**RE: Mark 3S Holly Development
9300 Holly NE
Grading and Drainage Plan
Engineer's Stamp Date 1/30/18 (File: C20D062)**

Based on the information provided in your submittal received on 1/31/18, this plan cannot be approved until the following are corrected:

NO.	DATE	BY	REVISIONS	JOB NO.
1	02/18	GM	COA HYDROLOGY COMMENTS	2017.014.4
				DATE 01-2018
				SHEET CG-101-A

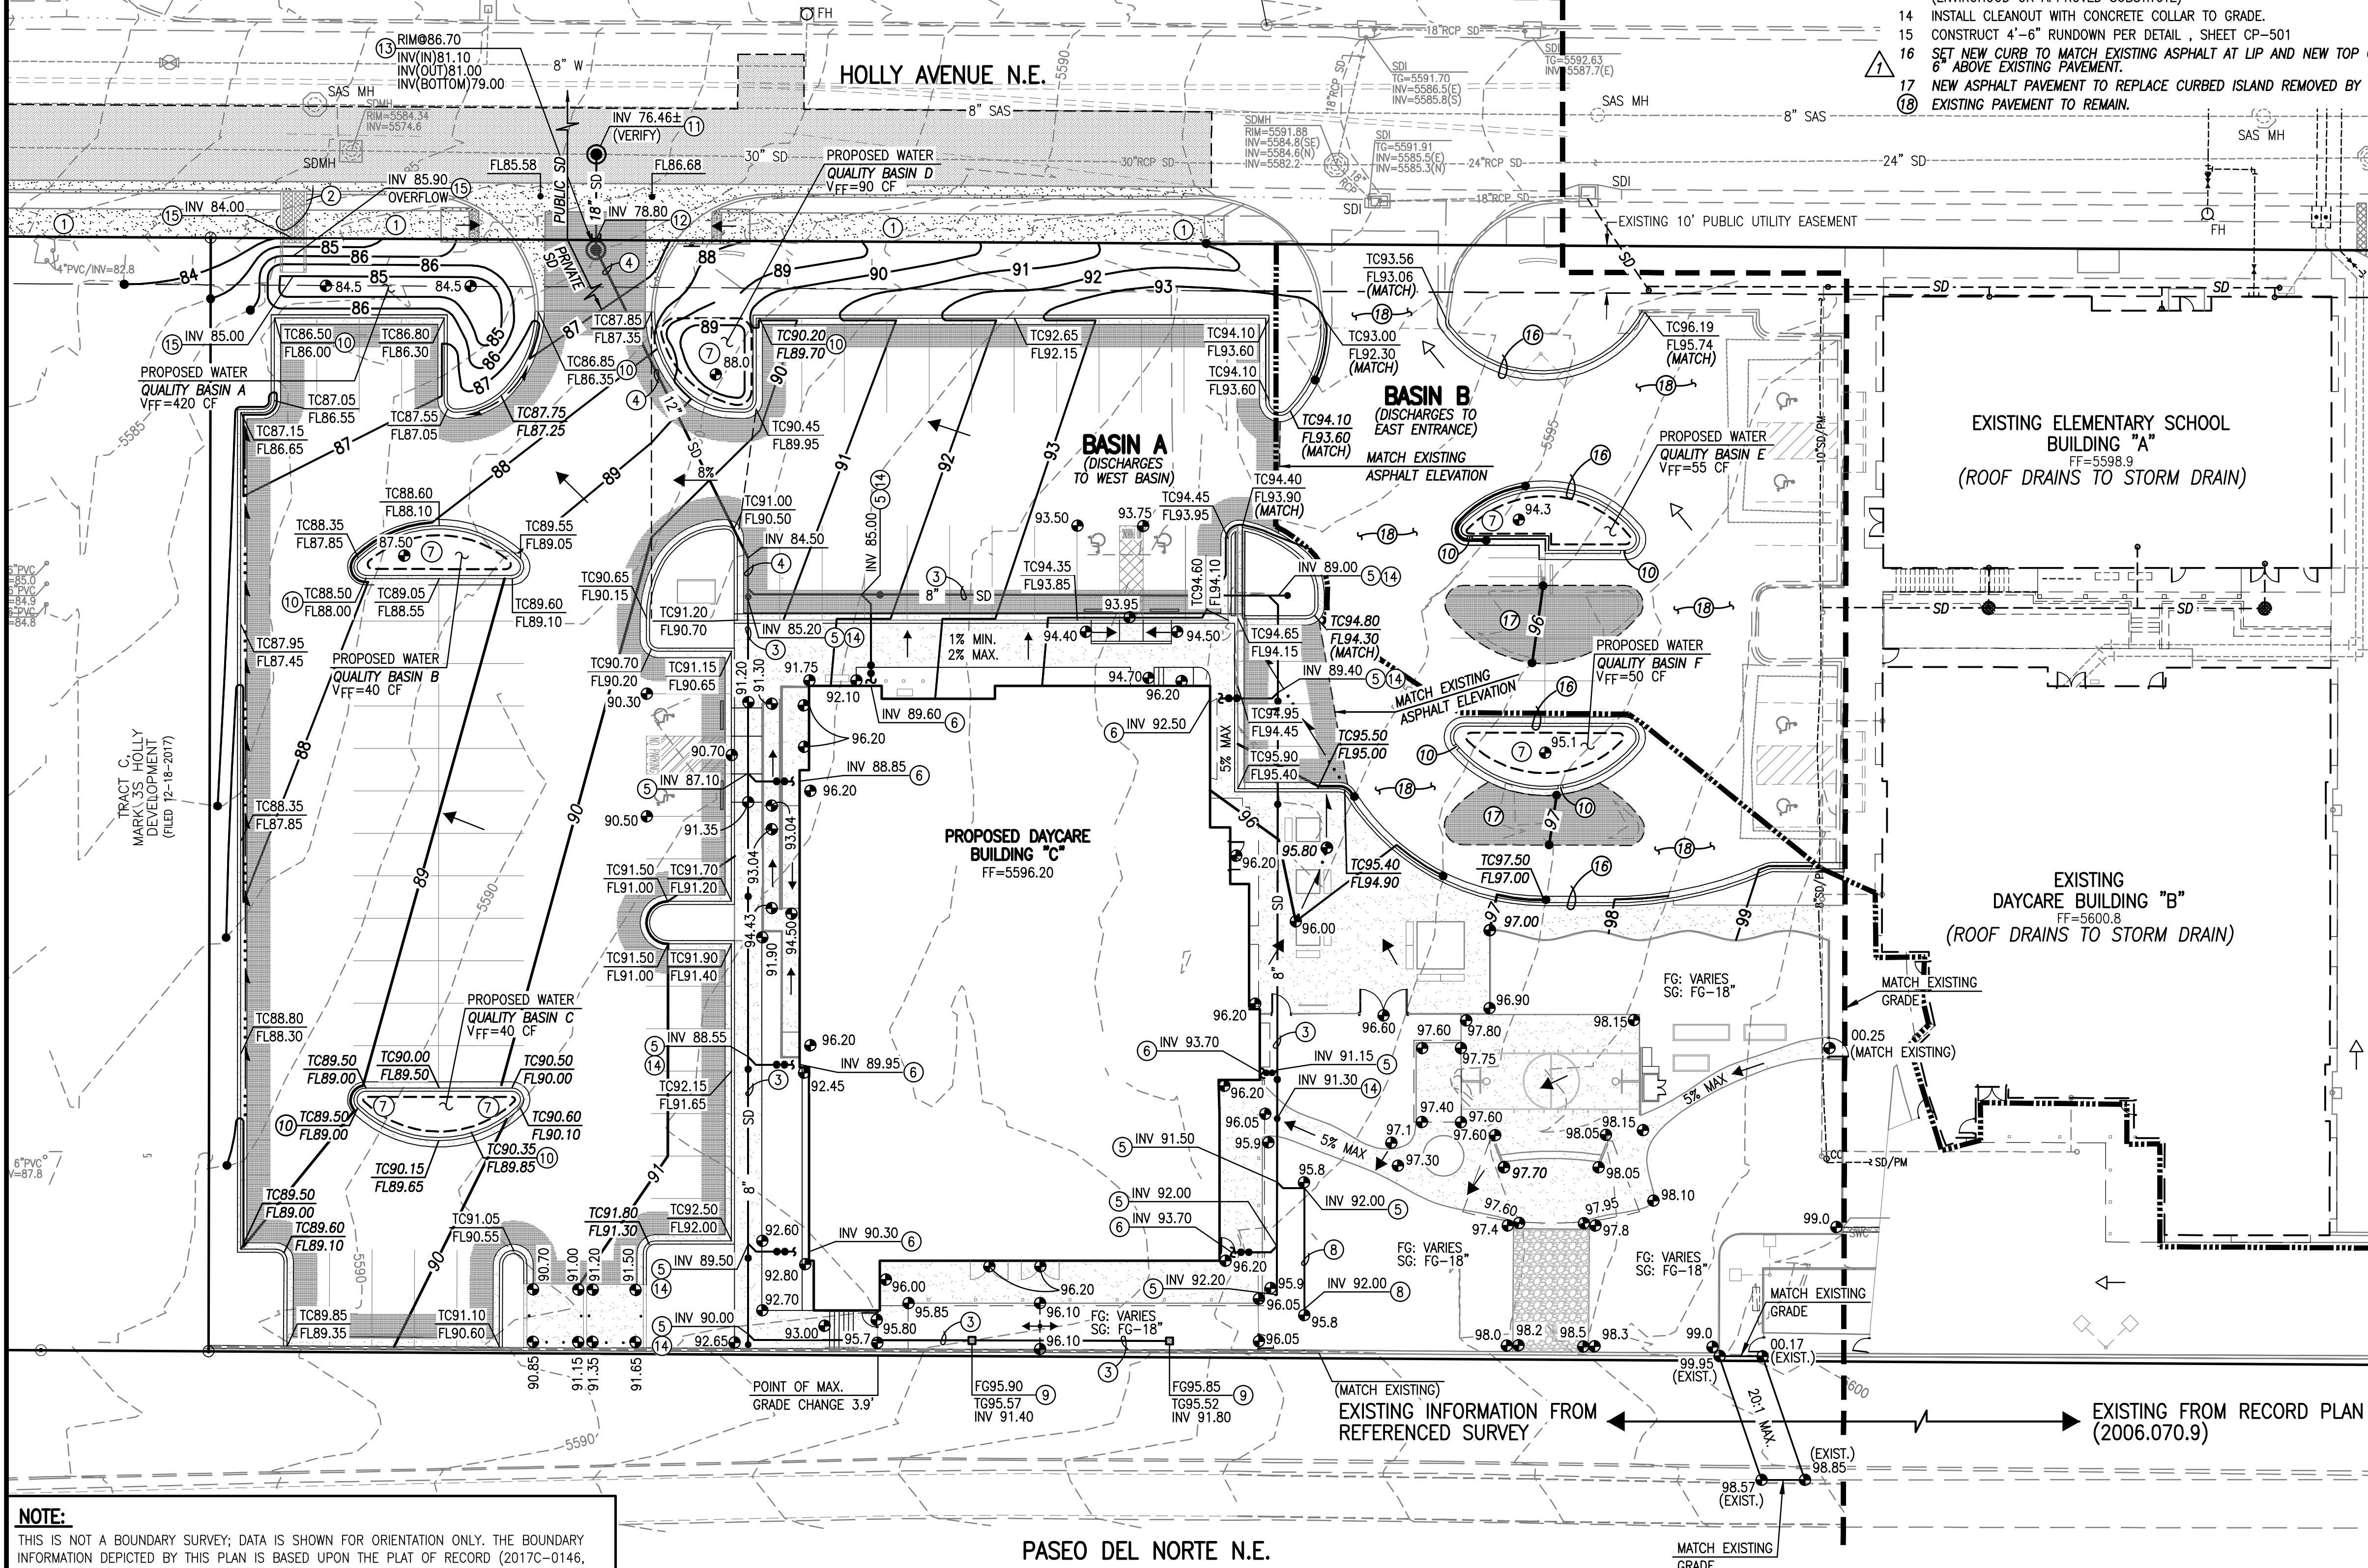
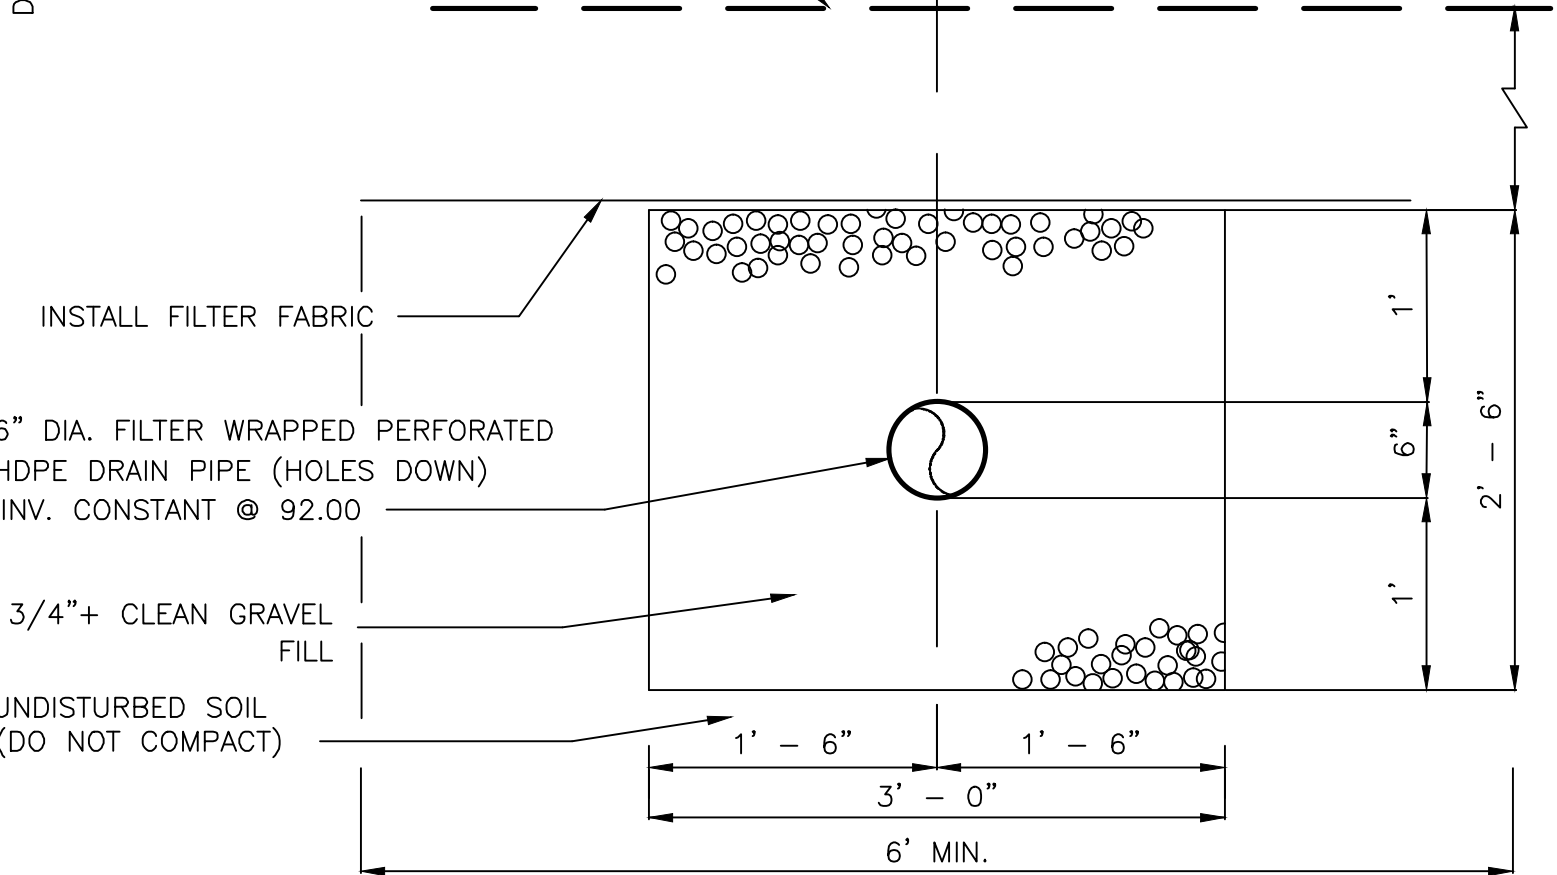
1. Provide a subbasin delineation map showing the area draining to each first flush pond. Quantify impervious v. pervious area.
2. Each pond needs to be sized for the impervious area draining to it.
3. For redevelopment, the first flush requirement is calculated as: $\text{Volume} = 0.26'' \times \text{Rebuilt Impervious Area}$. The rebuilt impervious area is the impervious area for the new school expansion, plus the impervious area of repaved parking lot/play area at the existing school.
4. The storm drain connection in the Public ROW needs to be 18" min. RCP class 3. Also add a Public/Private divide line at the new private manhole.
5. Provide a detail for the new retaining wall adjacent to Paseo del Norte ROW. Demonstrate that the adjacent ROW is not damaged or constrained in its use by the new wall.

6. A Private Facility Drainage Covenant is required for the stormwater quality ponds. The original notarized form, exhibit A (legible on 8.5x11 paper), and recording fee (\$25, payable to City of Albuquerque) must be turned into DRC (4th, Plaza del Sol) for routing. Please contact Charlotte LaBadie (clabadie@cabq.gov, 924-3996) or Madeline Carruthers (mtafoya@cabq.gov, 924-3997) regarding the routing and recording process for covenants.
7. Correct the depth of gravel under the perforated pipe (1' vs 1").
